DEPARTMENT OF PARKS AND COMMUNITY SERVICES

June 28, 2023

Subject: Mayberry Filing No.4 - (SF2317)

Final Plat of
MAYBERRY, COLORADO SPRINGS FILING NO. 4
 Being a replat of Tract A, MAYBERRY, COLORADO SPRINGS FILING NO. 3
 Lying the Northeast Quarter of Section 14, Township 14 South, Range 63 West of the 6th Principal Meridian
 County of El Paso (Unincorporated), State of Colorado

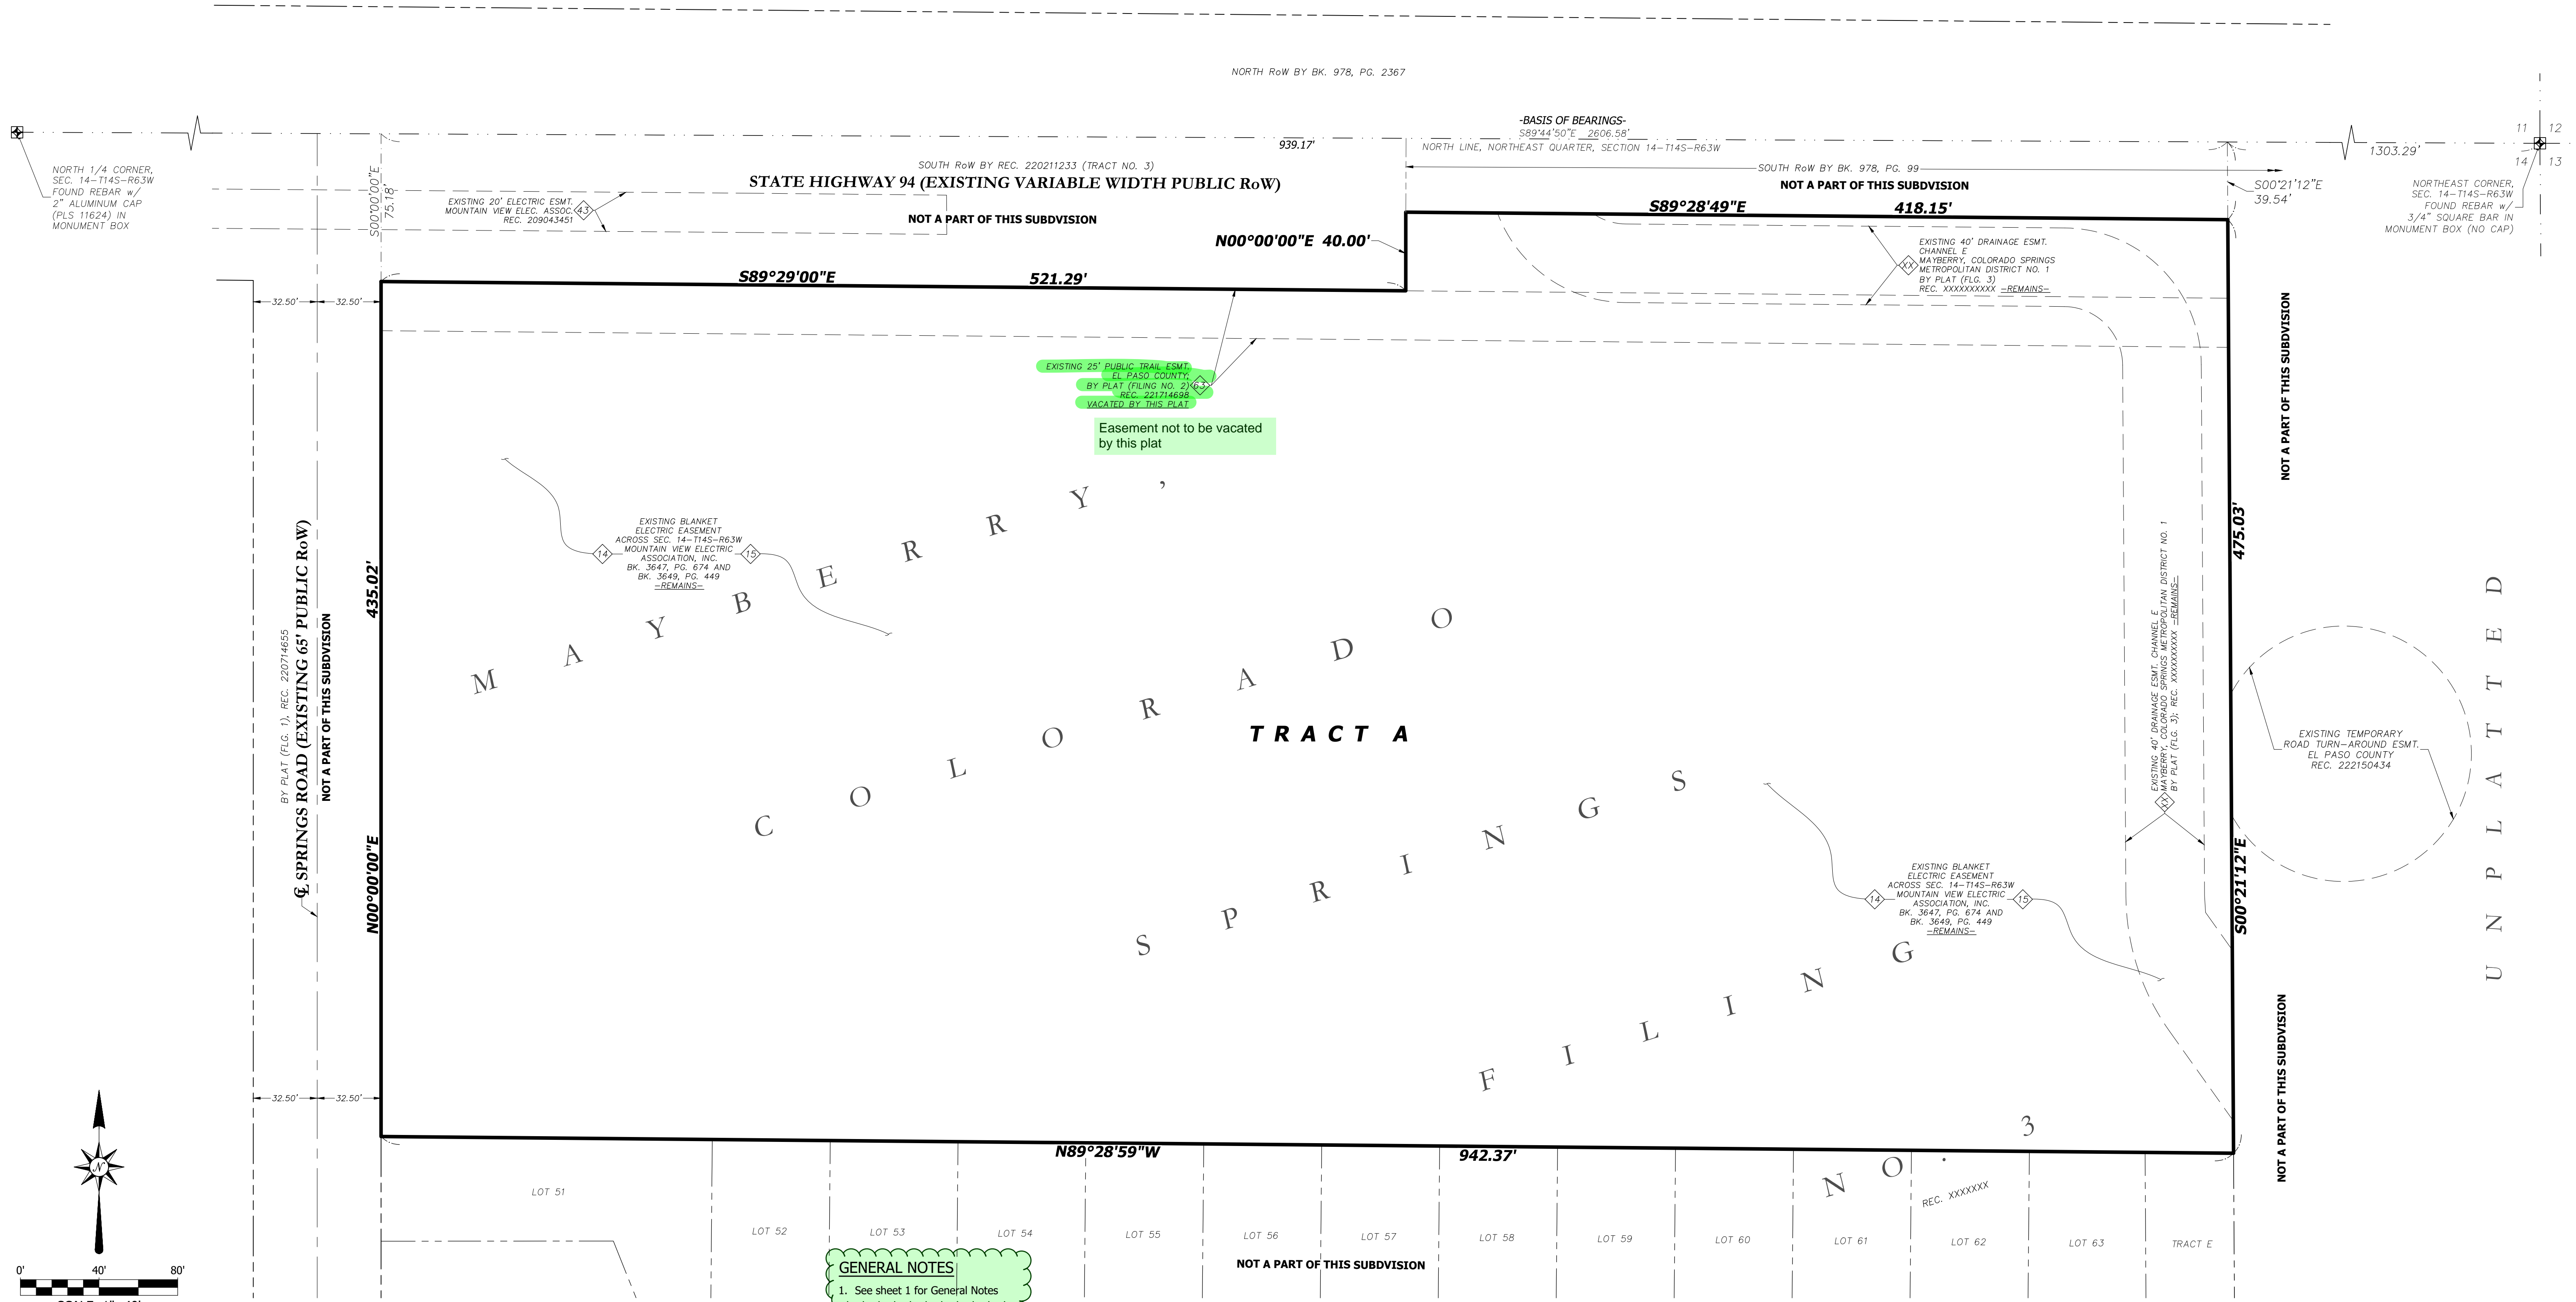
County Parks requests trail easements where development projects impact proposed County trails. As it pertains to this application, the County requests that the landowner provide a 25-foot public trail easement along the south side of Highway 94 that allows for the construction and maintenance by El Paso County of a Secondary Regional Trail, and this easement shall be shown and dedicated to El Paso County on the Final Plat. The trail easement is shown on the Filing No.4 Final Plat as "Existing 25' Trail Easement El Paso County by Plat (Filing No.2) REC. 221714698 VACATED BY THIS PLAT." The trail easement is required by the El Paso County Land Development code and shall be noted as "REMAINS" vs. "VACATED." County Parks has previously identified this error and made similar comments when reviewing Filing No. 3 in 2021 and 2022. County Parks does not have any documentation to support the vacation of the trail easement, nor has the applicant provided any justification in the application to forgo the trail easement.

Recommend that the Planning Commission and the Board of County Commissioners include the following conditions when considering and/or approving the Mayberry Filing No.4 Final Plat: (1) provide a 25-foot public trail easement along the south side of Highway 94 outside of the public right-of-way that allows for the construction and maintenance by El Paso County of a

Primary Regional Trail, and this easement shall be shown and dedicated to El Paso County on the Final Plat. (2) correct the final plat note that incorrectly states vacation of the required trail easement.
